PLANNING CONSULTATION RESPONSE

Application No	2026/0619
Proposal	Retrospective change of use of the former Lundwood Social Club (Sui Generis) to an MOT and tyre service unit (Sui Generis) including installation of roller shutter; and proposed change of use Lundwood Social Club (Sui Generis) to Class E(a) retail unit with associated works.
Address	Lundwood Social Club, Pontefract Road, Lundwood, Barnsley, S71 5PN
Date of Consultation Reply	08/09/2026
Consultee	Katie Lawrence, Planning Ecologist

Consultation Assessment and Justification

FRONT ELEVATION - EAST

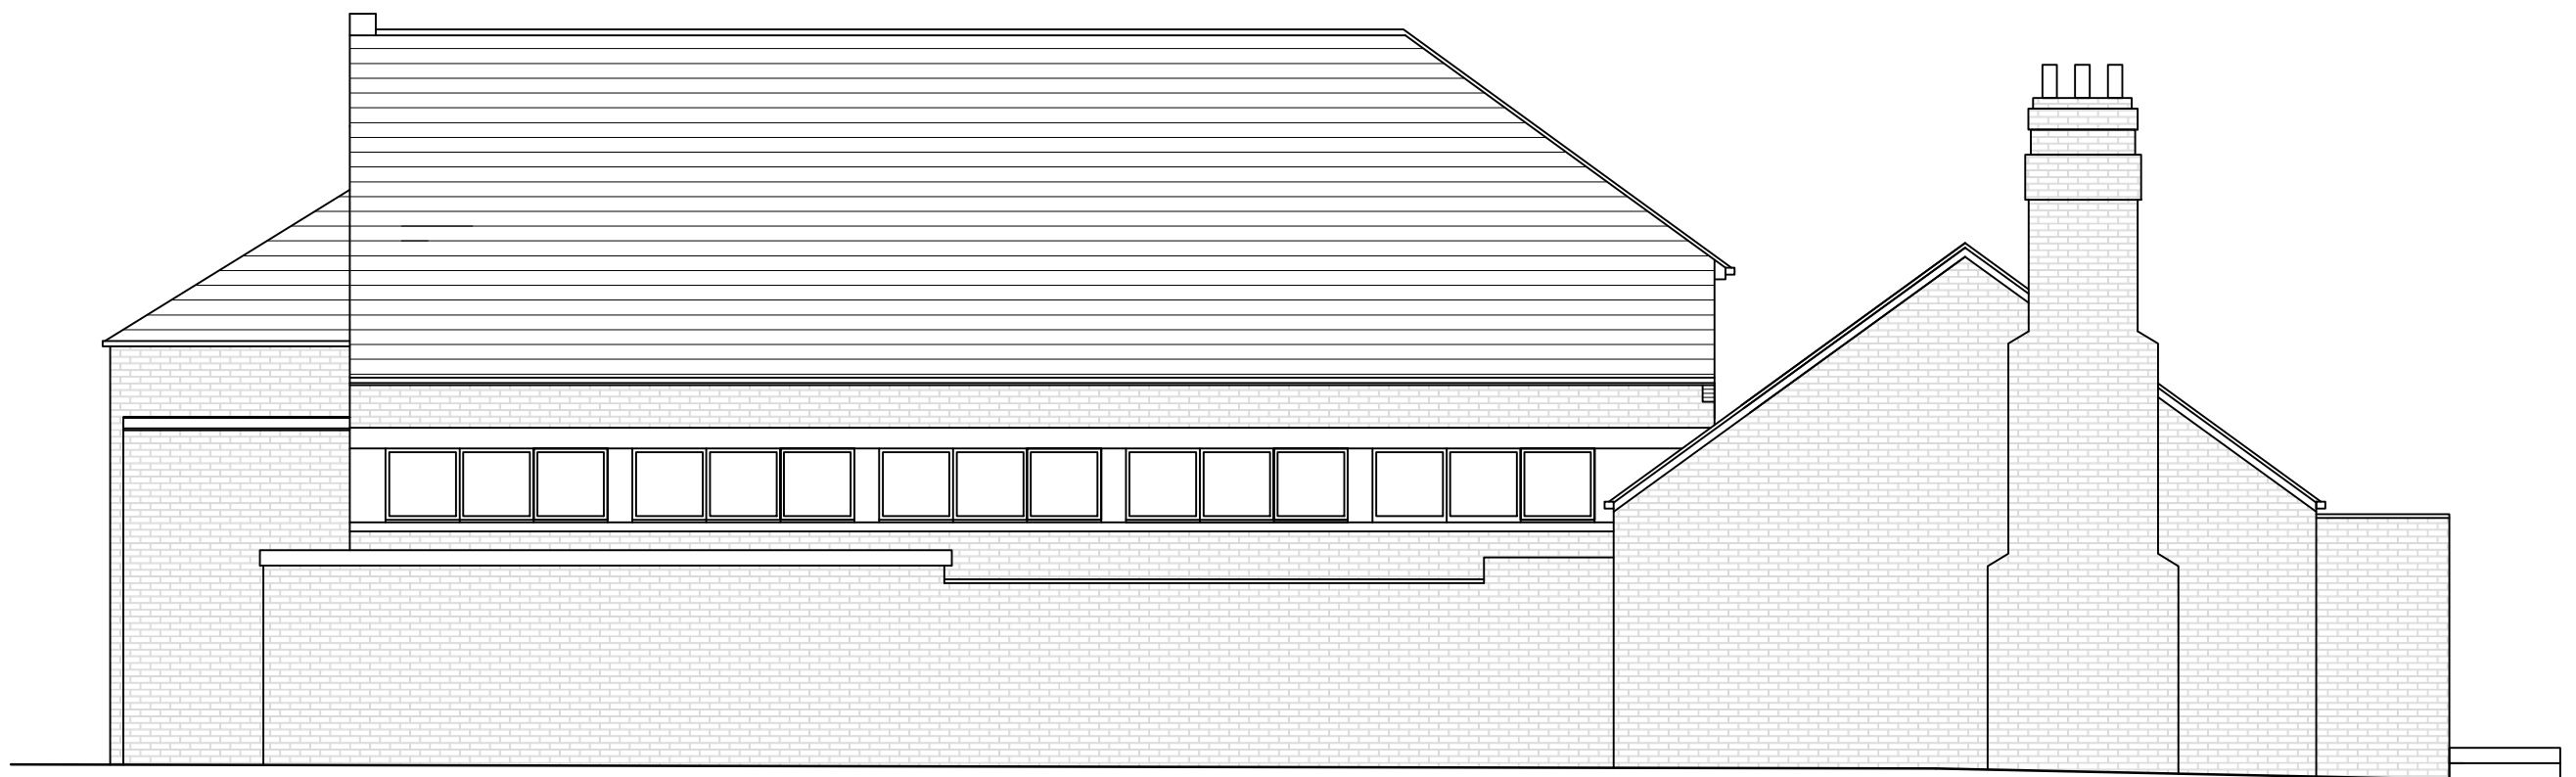
- The bat report includes no recommendations for the installation of bat and bird boxes on the building affected by works. Such measures can be secured by a planning condition, in line with the Biodiversity and Geodiversity SPD and the NPPF. Alternatively, plans can be updated to show proposed box types and locations and submitted as part of the application. Suggested condition wording is set out below.

A scheme for biodiversity enhancement, such as the incorporation of permanent bat roosting feature(s) and nesting opportunities for birds, shall be submitted to and agreed in writing with the Local Planning Authority. The approved details thereafter shall be implemented, retained and maintained for their designed purpose in accordance with the approved scheme.

- Description, design or specification of the type of feature(s) or measure(s) to be undertaken;
- Materials and construction to ensure long lifespan of the feature/measure
- A drawing(s) showing the location and where appropriate the elevation of the features or measures to be installed or undertaken.
- When the features or measures will be installed within the construction, occupation, or phase of the development.
